Ribble Valley Borough Council  
Housing & Development Control

Application no: **3/2023/1008**

Address: **Wellsprings Hotel Clitheroe Road Sabden BB7 9HN**

Proposal: **Proposed refurbishment of existing ground-floor caretaker apartment and creation of four new holiday let apartments, three on the ground floor and one on the first floor.**

Scale:	Existing site layout
1:200

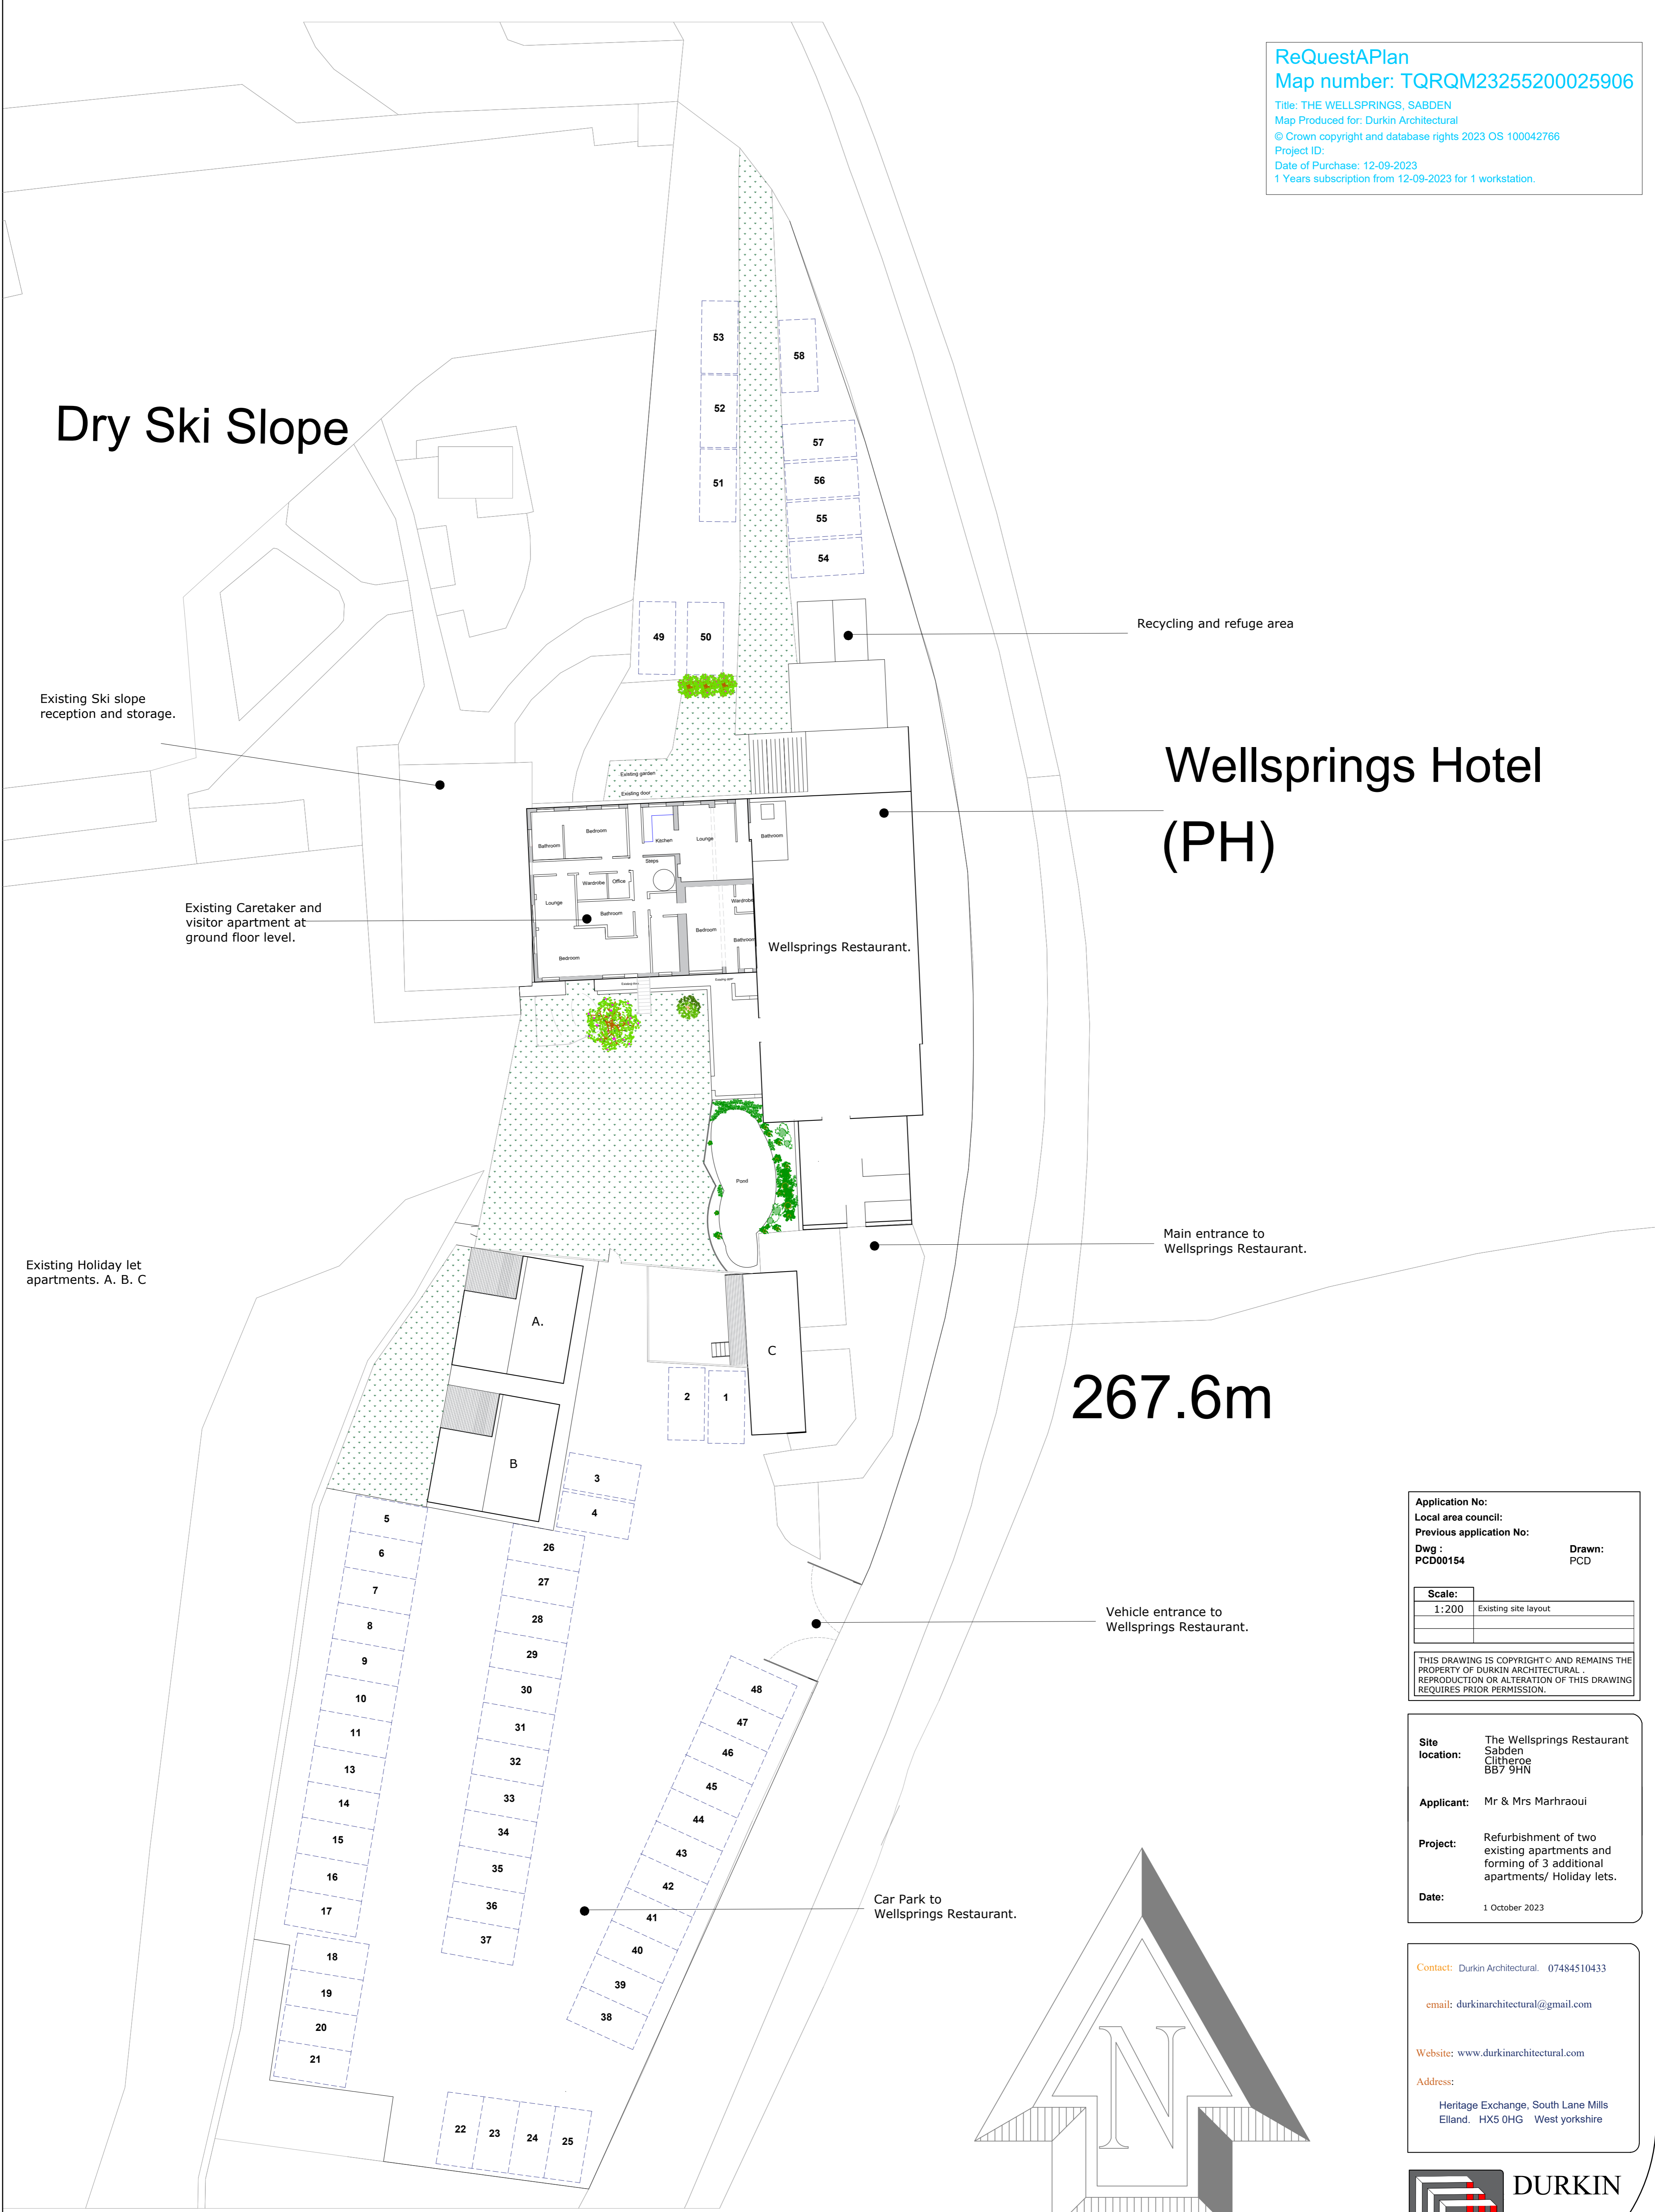
The site has two car parks which are provided off Clitheroe Road, a C classified road subject to a 60mph speed limit. The main car park is used for the customers of the Wellsprings Restaurant and the two existing holiday lets providing 48 car parking spaces. While the other car park provides up to 10 car parking spaces for employees, with 5 being provided by the roadside and the other 5 via a separate access leading to the lower parking area, as shown on Durkin drawing number PCD00154 titled "Existing Site Layout".

As advised in the previous highway comments dated 9th May 2024, the lower parking area will remain as existing following the proposal, which is welcomed, with the LHA unwilling to formalise the use of the area. The LHA will also continue to advise all employees and servicing vehicles to use the main car park when accessing the site for highway safety reasons but note that the area is likely to have an existing lawful use.
